**EL PASO COUNTY PLANNING AND
 COMMUNITY DEVELOPMENT
 DEPARTMENT**

GRADING AND EROSION CONTROL PLAN CHECKLIST
The Villas at Claremont Ranch

Revised: July 2019

VTC-1. AGGREGATE VEHICLE TRACKING CONTROL

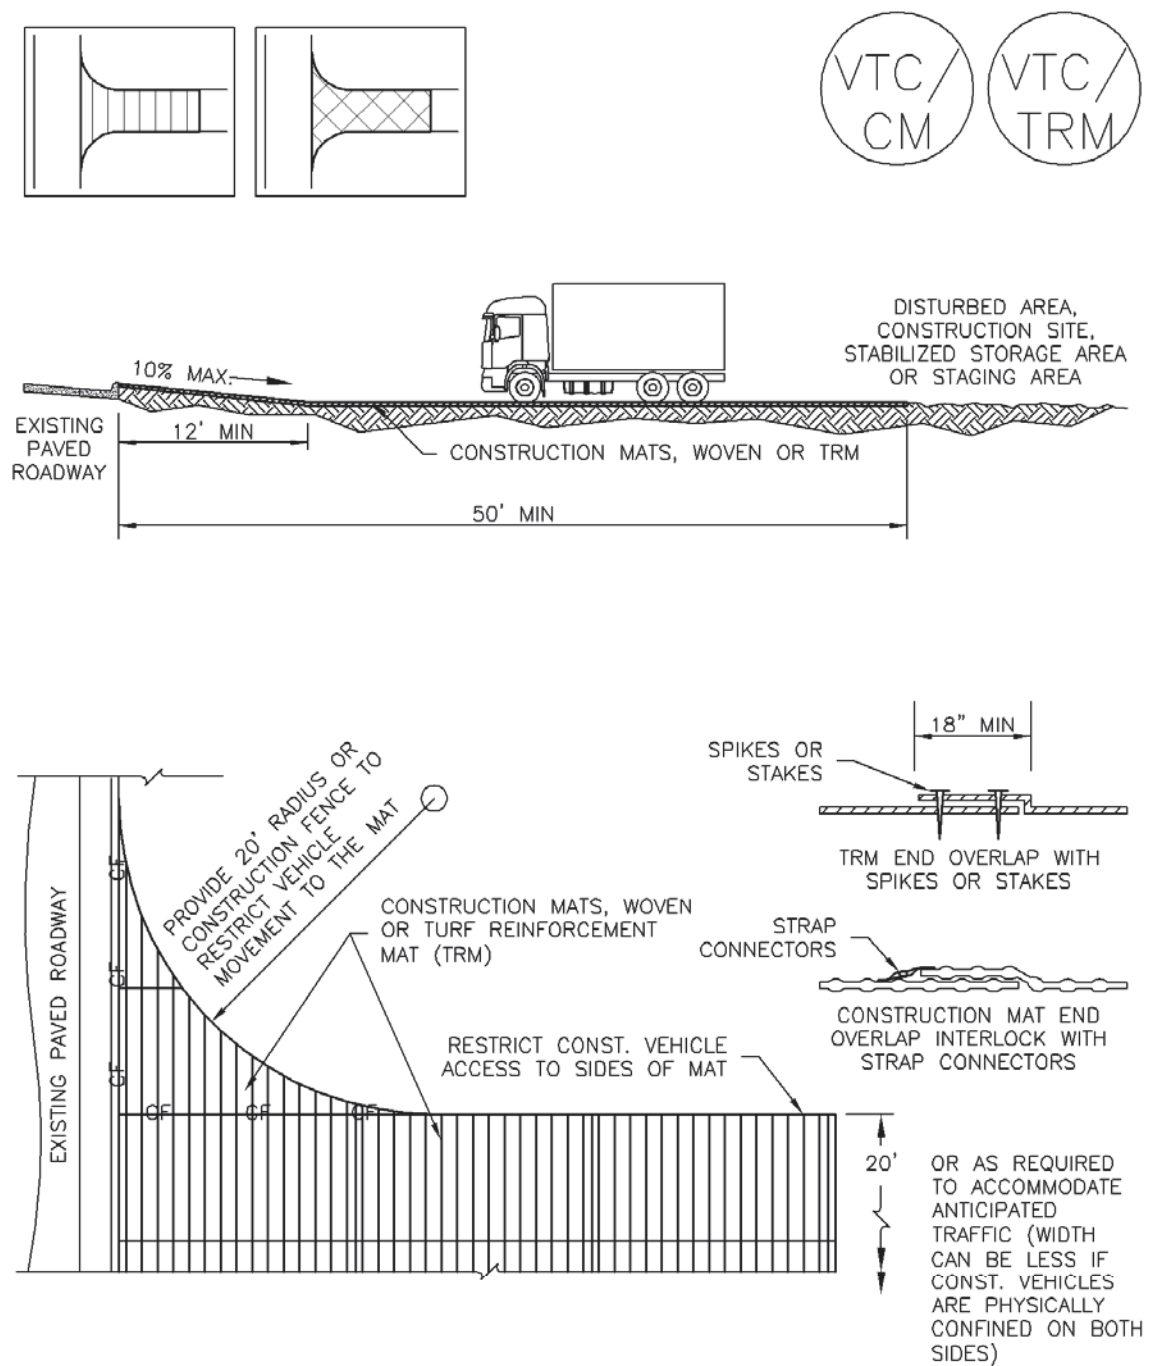
v	All proposed temporary construction control measures, structural and non-structural. Temporary construction control measures shall be identified by phase of implementation to include "initial," "interim," and "final" or shown on separate phased maps identifying each phase.	X	N
w	Vehicle tracking provided at all construction entrances/exits. Construction fencing, barricades, and/or signage provided at access points not to be used for construction.	X	Y
x	Temporary sediment ponds provided for disturbed drainage areas greater than 1 acre.	X	Y
y	Dewatering operations to include locations of diversion, pump and discharge(s) as anticipated at time of design.	N/A	N/A
z	All proposed temporary construction control measure details. Custom or other jurisdiction's details used must meet or exceed EPC standards. See comment on VTC detail	X	N
